From: Amanda Scholes on behalf of Planning.Responses
Sent: 05 March 2021 08:12
To: Planning Scanning
Subject: FW: Planning Consultation on: LU/58/21/PL

Application No: LU/58/21/PL
Registered: 26th February 2021
Site Address: Land adjacent to Toddington Lane Farm Cottages Toddington Lane BN17 7PP
Grid Reference: 503545 103382
Description of Works: Erection of a semi-detached building comprising 2 No. 3 bedroom house with associated parking & landscaping. This application may affect the setting of a listed building and is in CIL Zone 2 and is CIL Liable as new dwellings.

Ecology

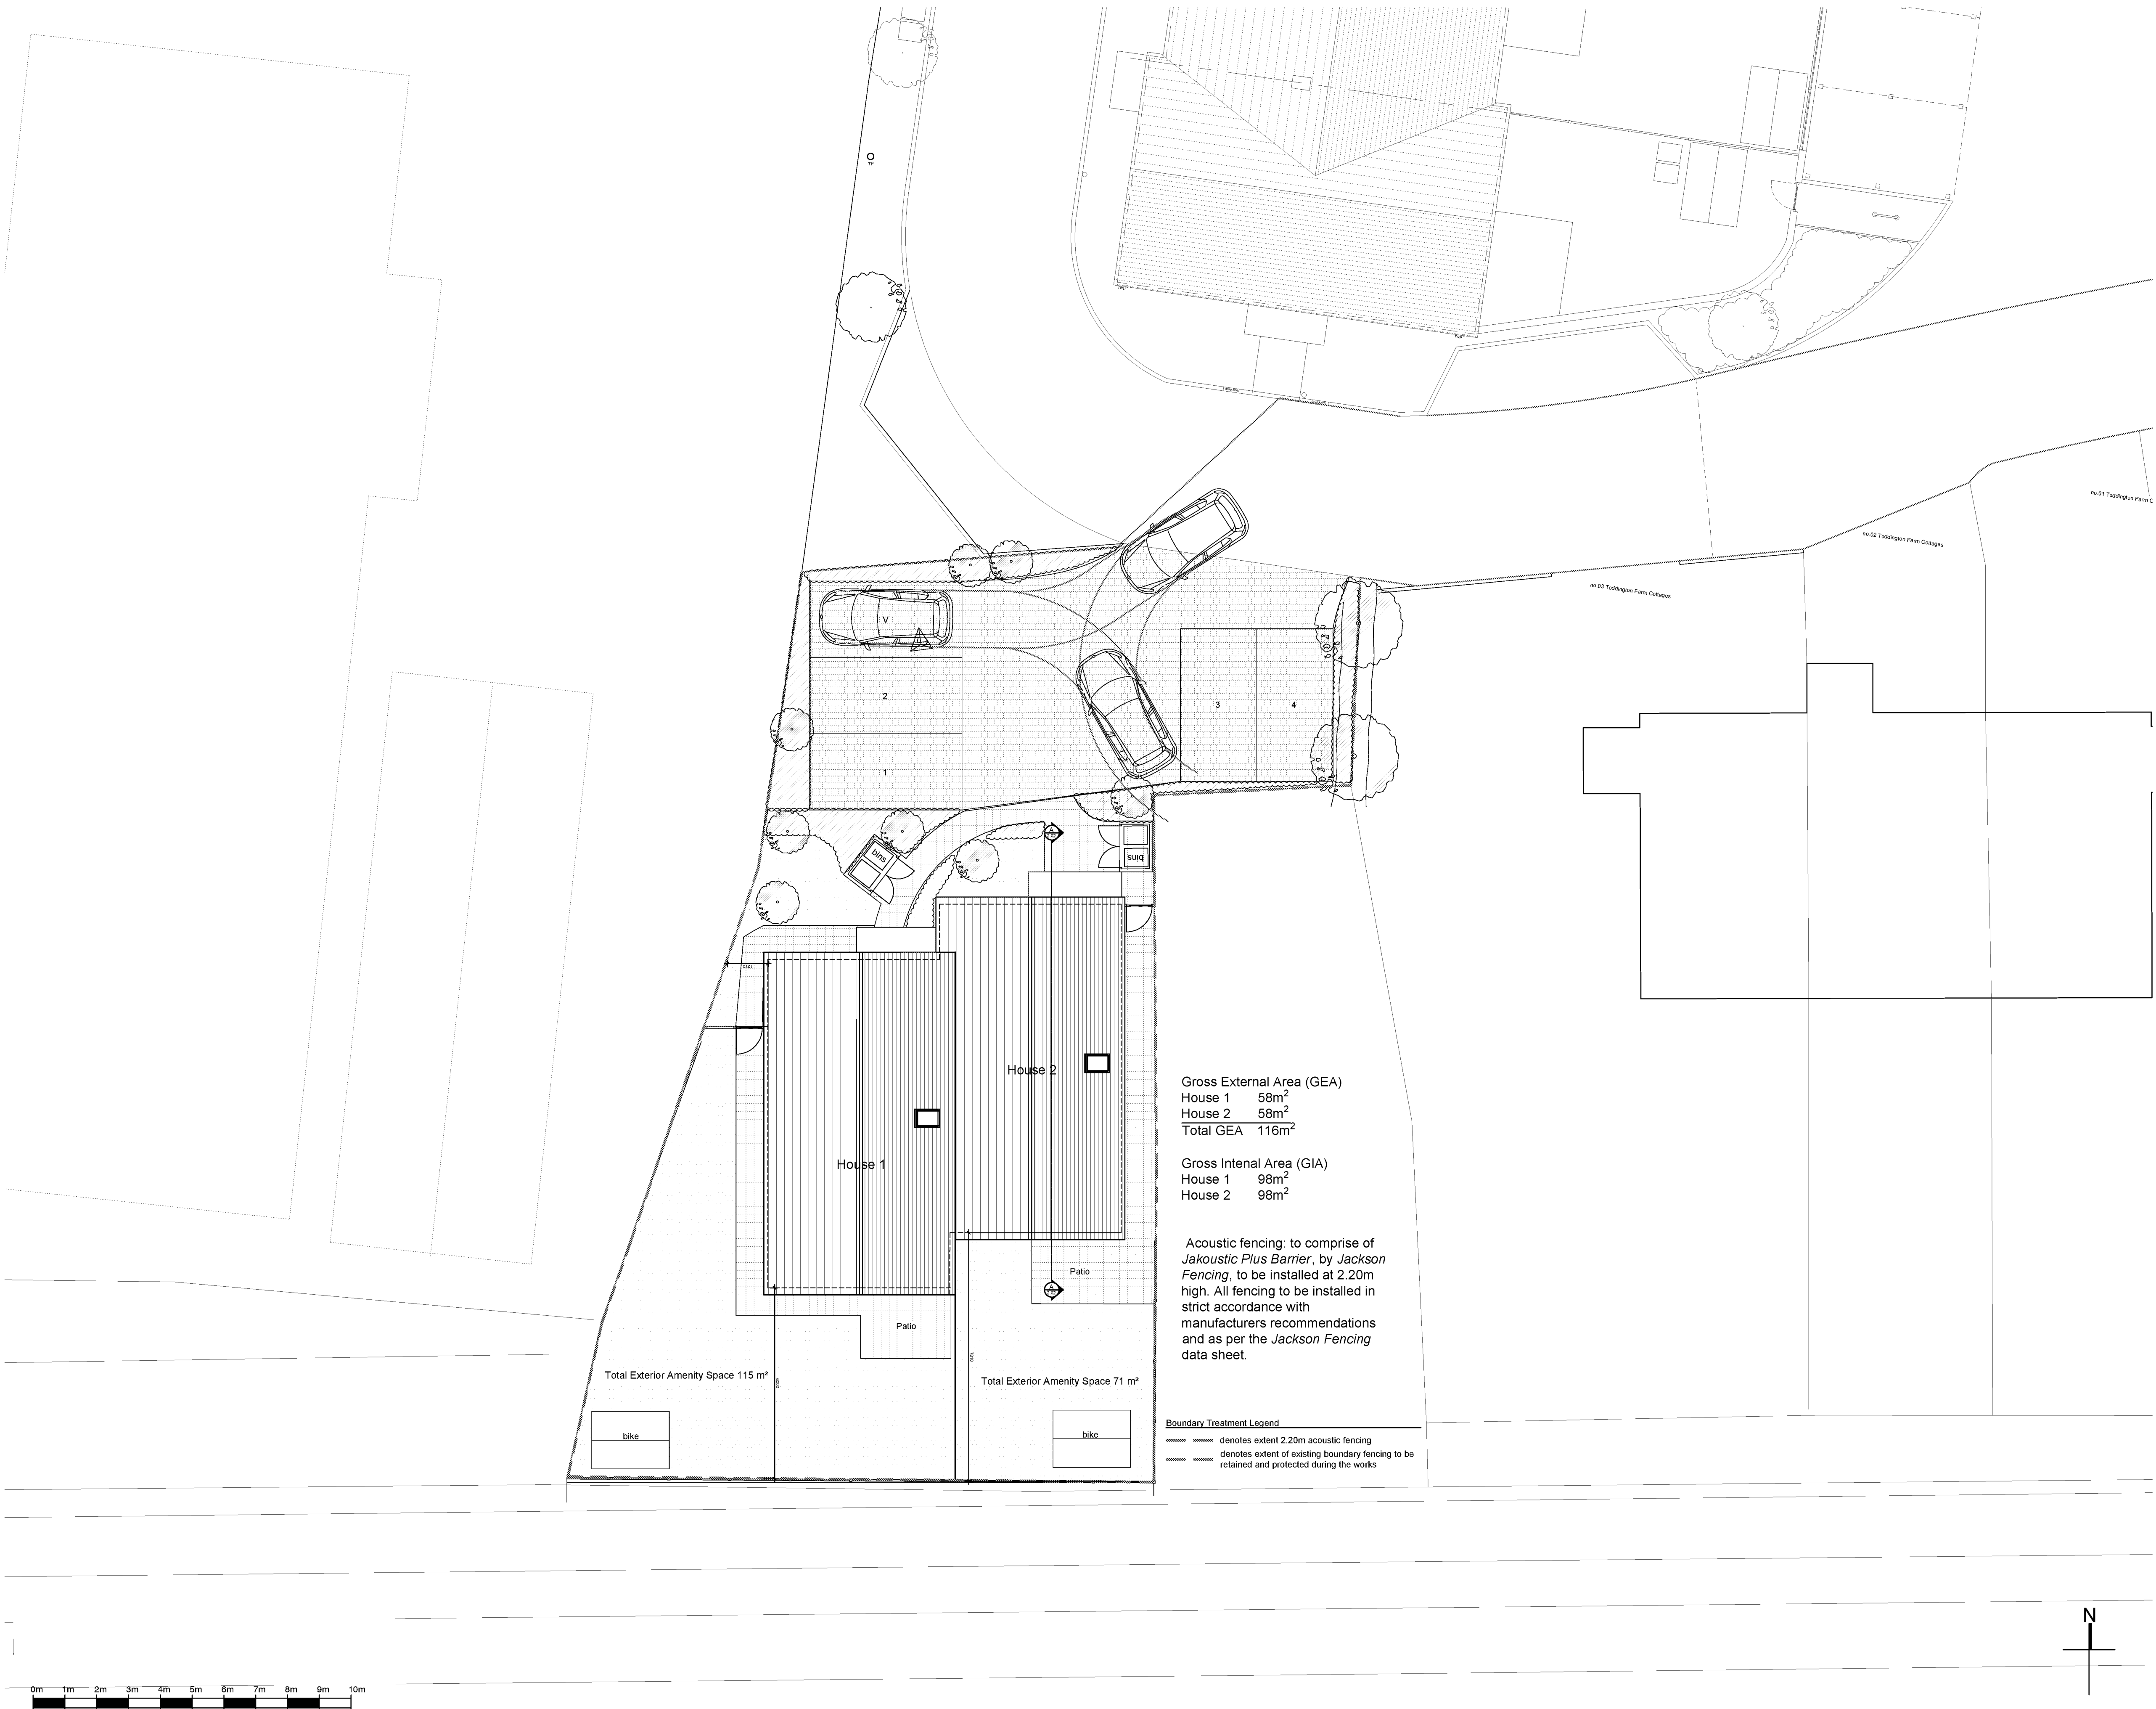
Further details are required on the intended replacement hedgerow at the southern boundary of the site.
